File: 2014/1778

Tuesday, 21 April 2015

**RE: BCA Assessment – DA Submission R4.0
Taronga Zoo Sumatran Tiger Adventure**

1 EXIT BUILDING - 'VIRTUAL SUPERMARKET' - PLAN
1:100

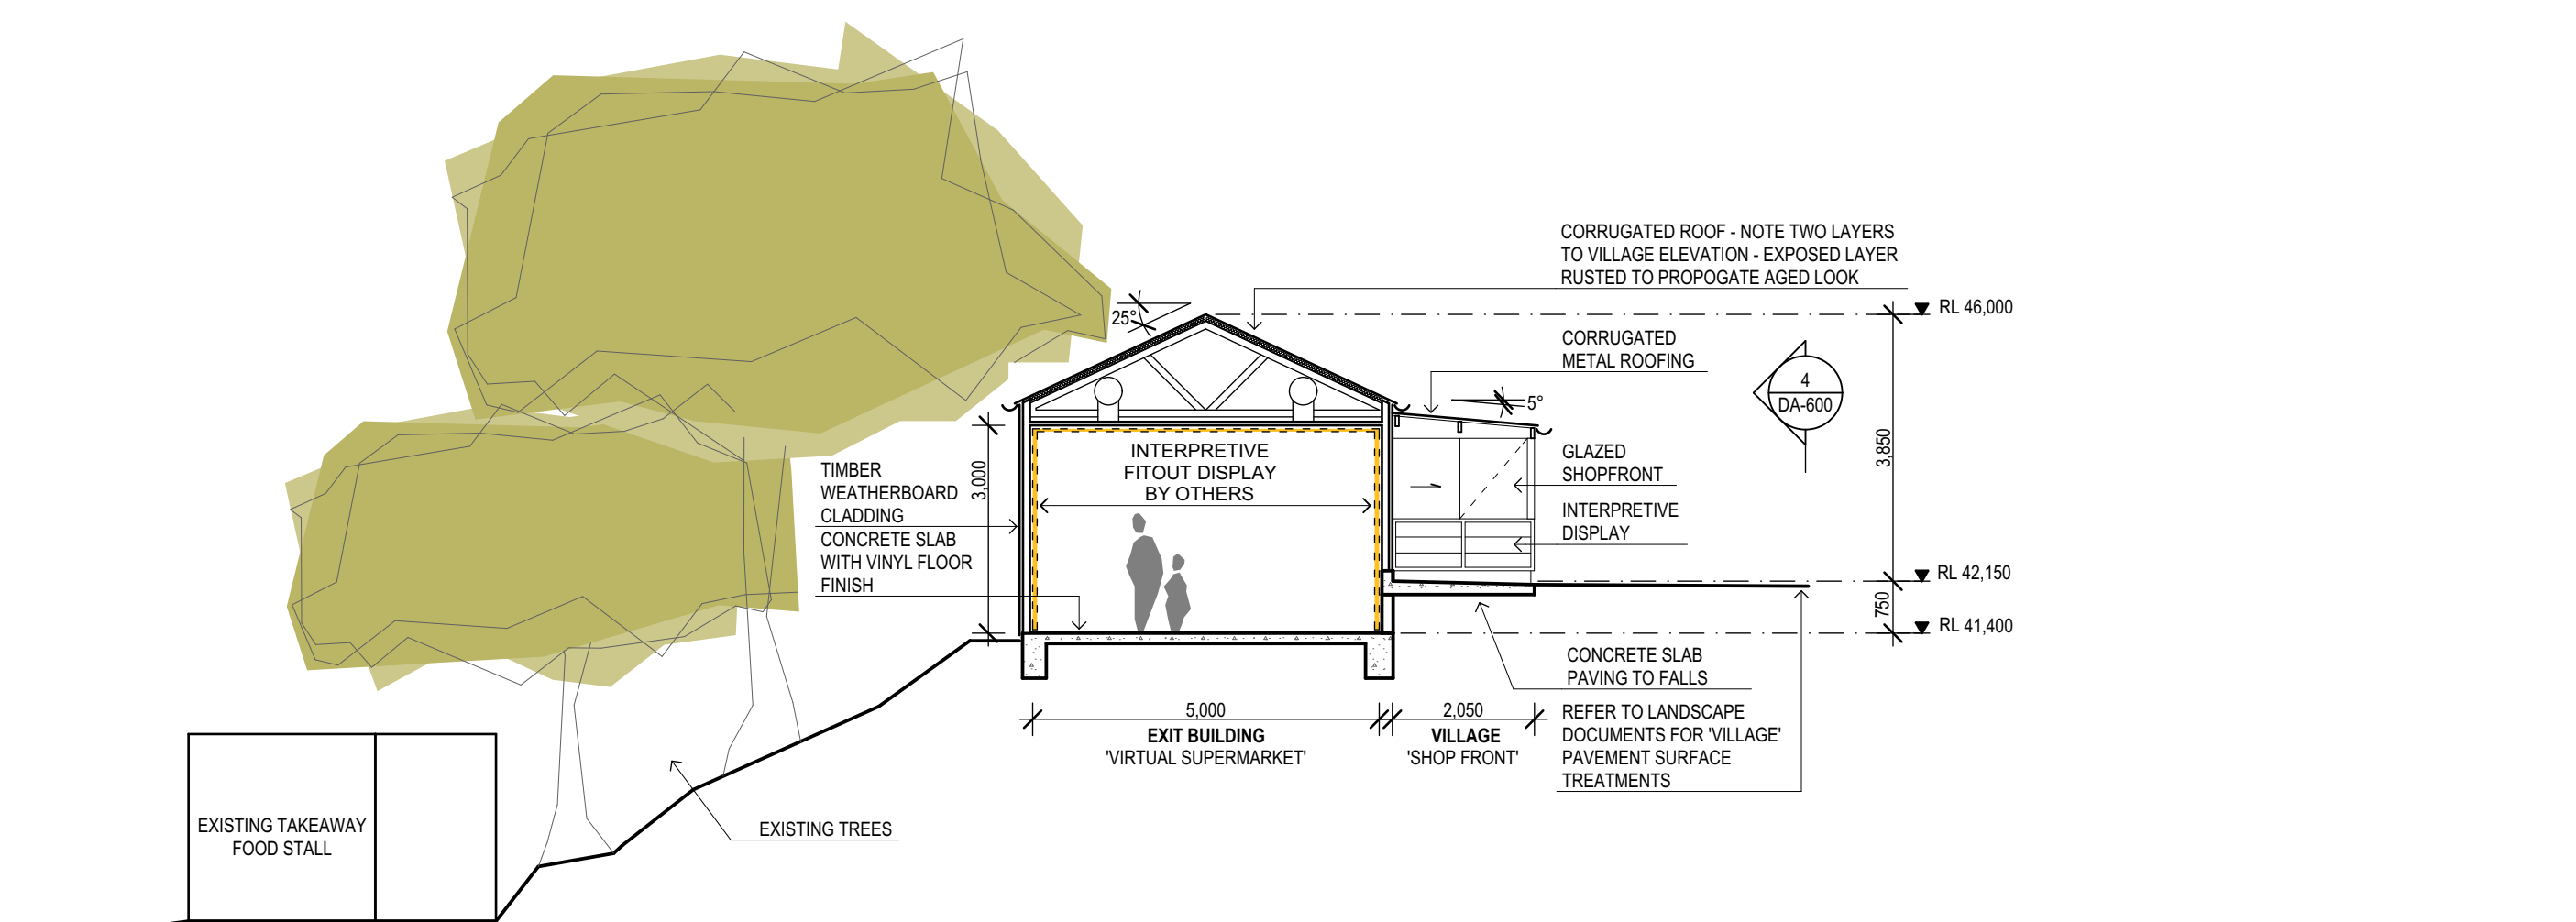
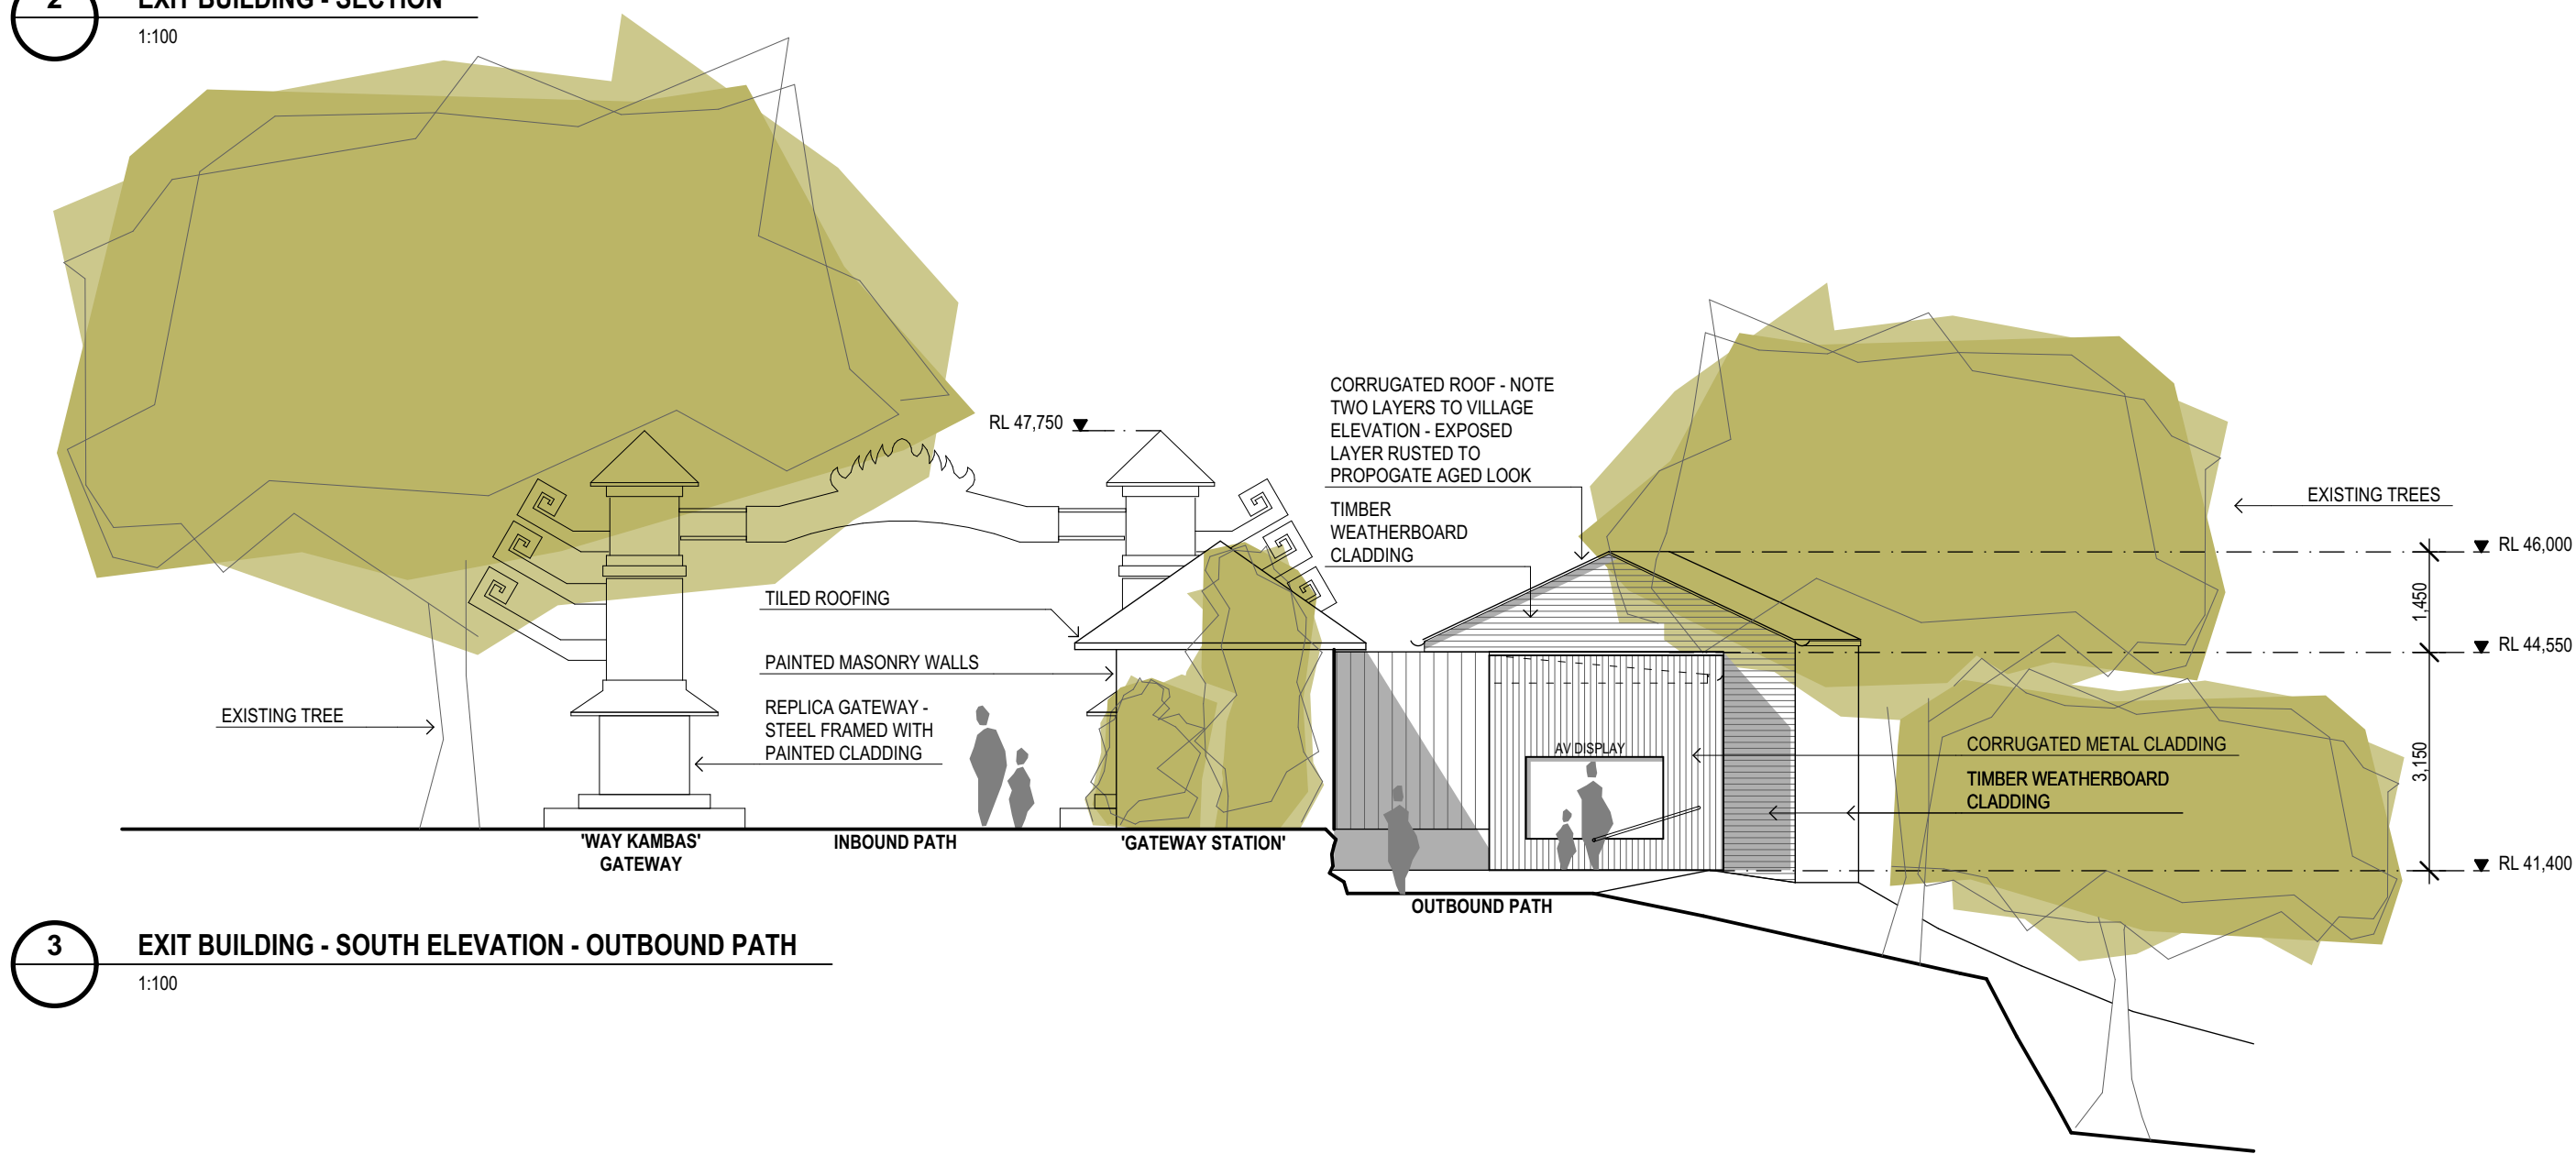
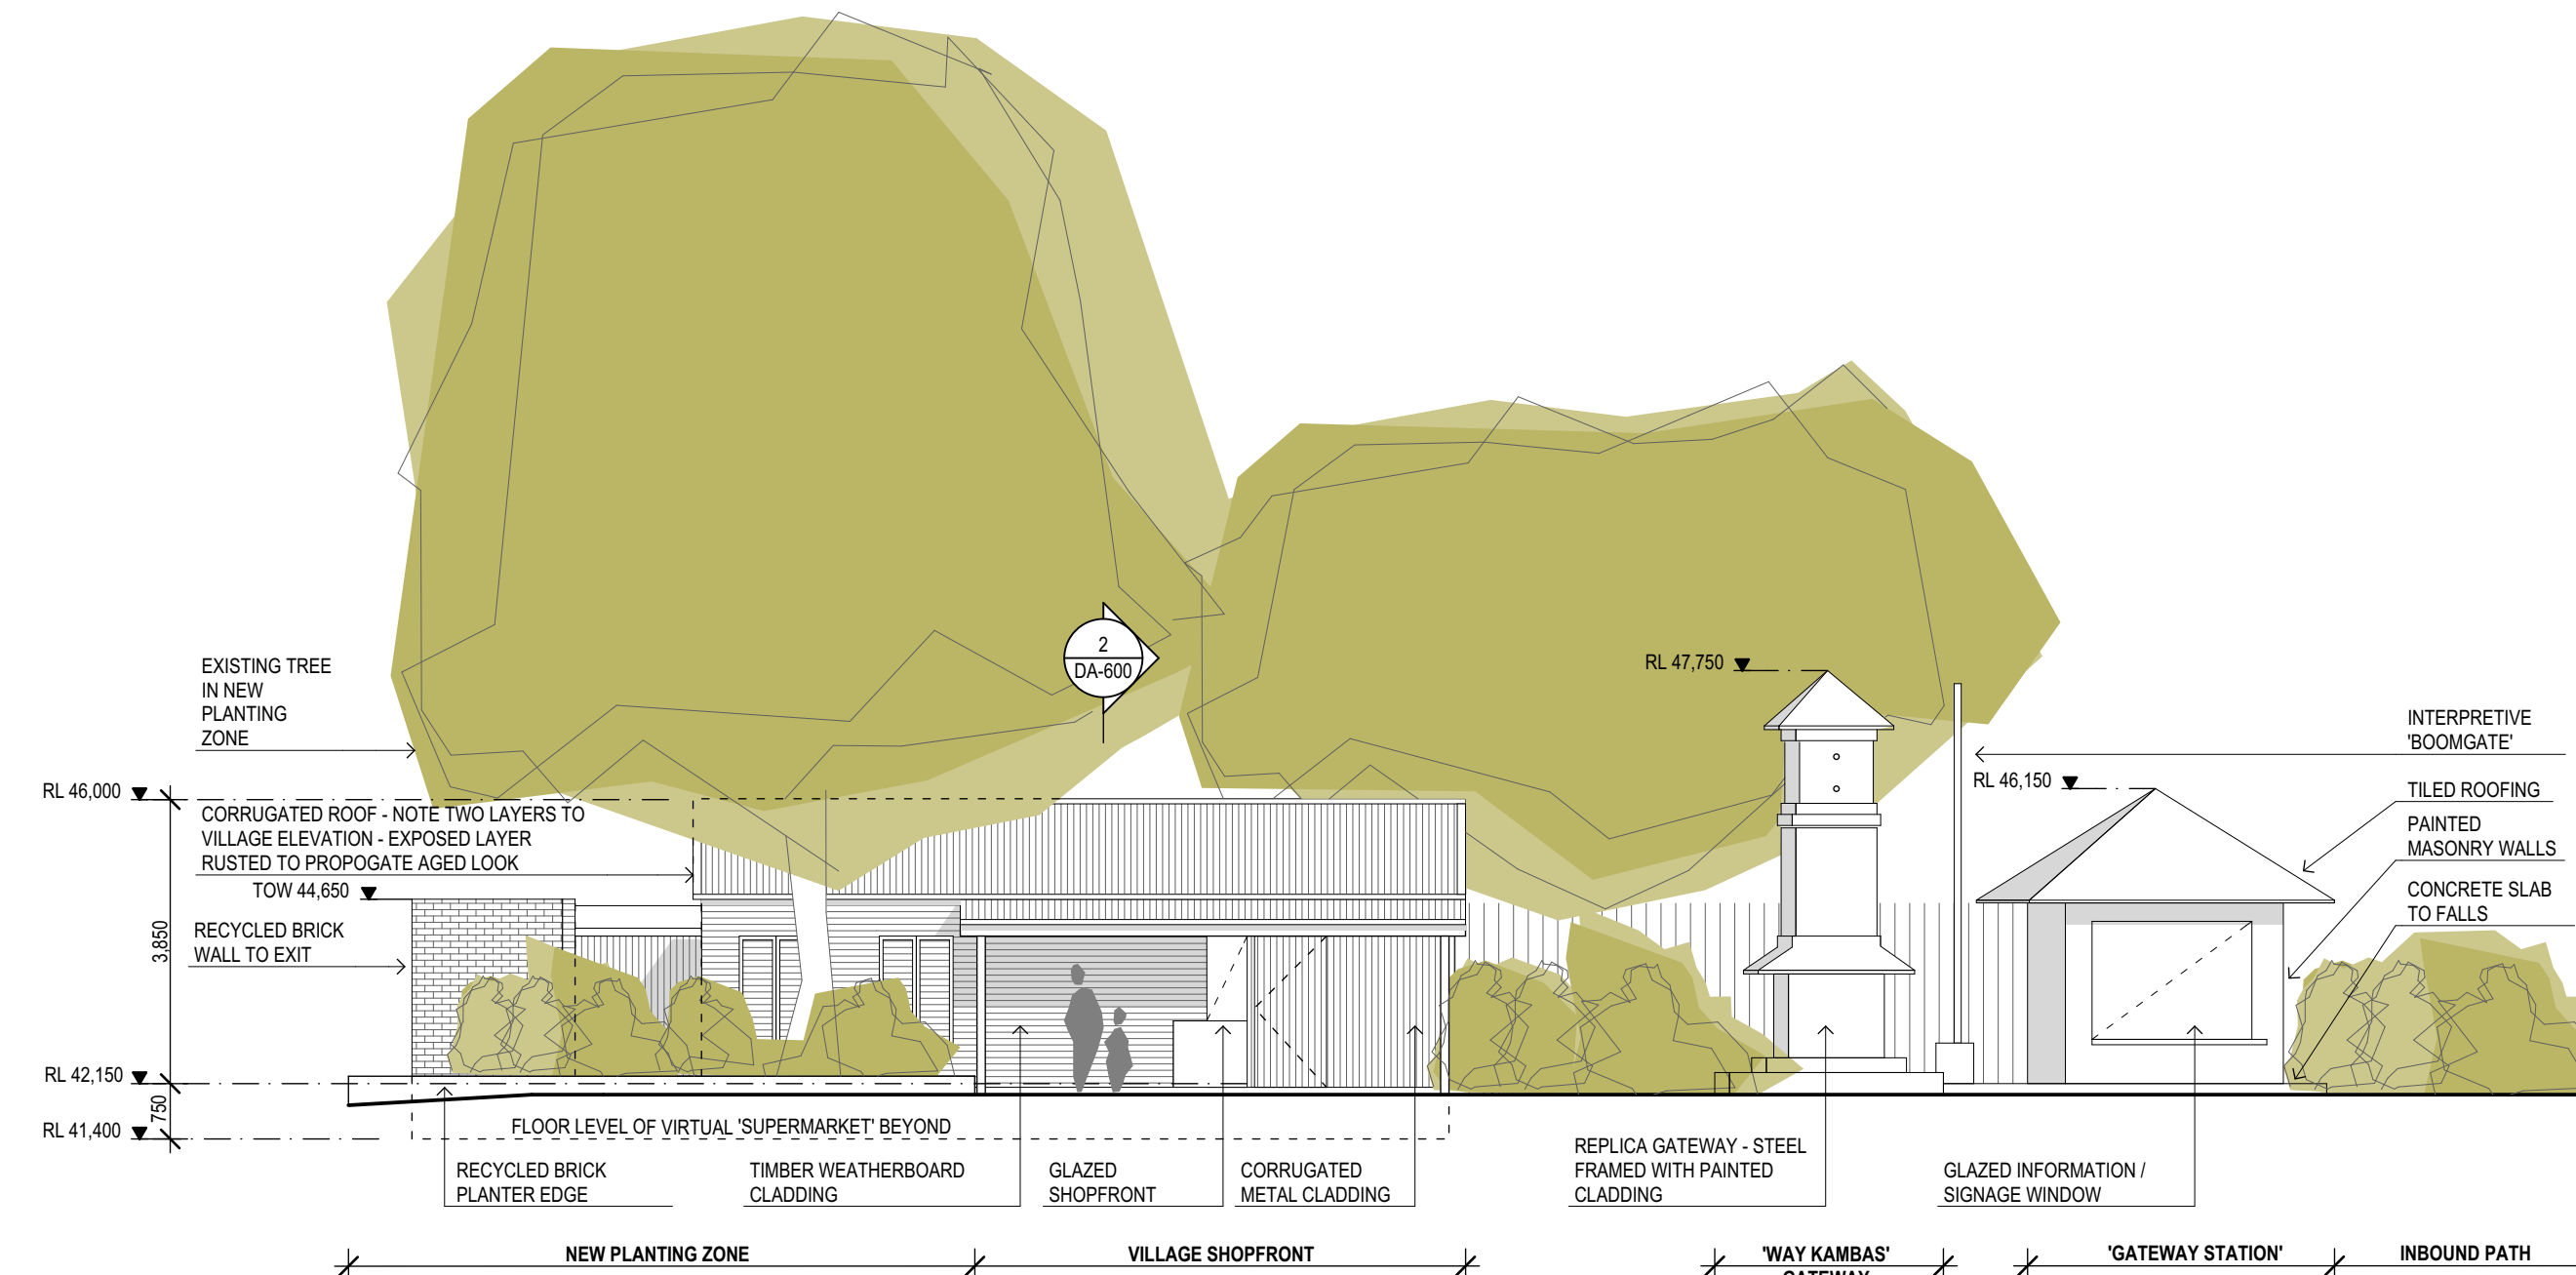
- Clause D2.19 requires the automatic sliding doors to the entry and exit to open automatically if there is a power failure to the door and have the capacity to be opened manually under a force of not more than 110N if there is a malfunction or failure of the power source.
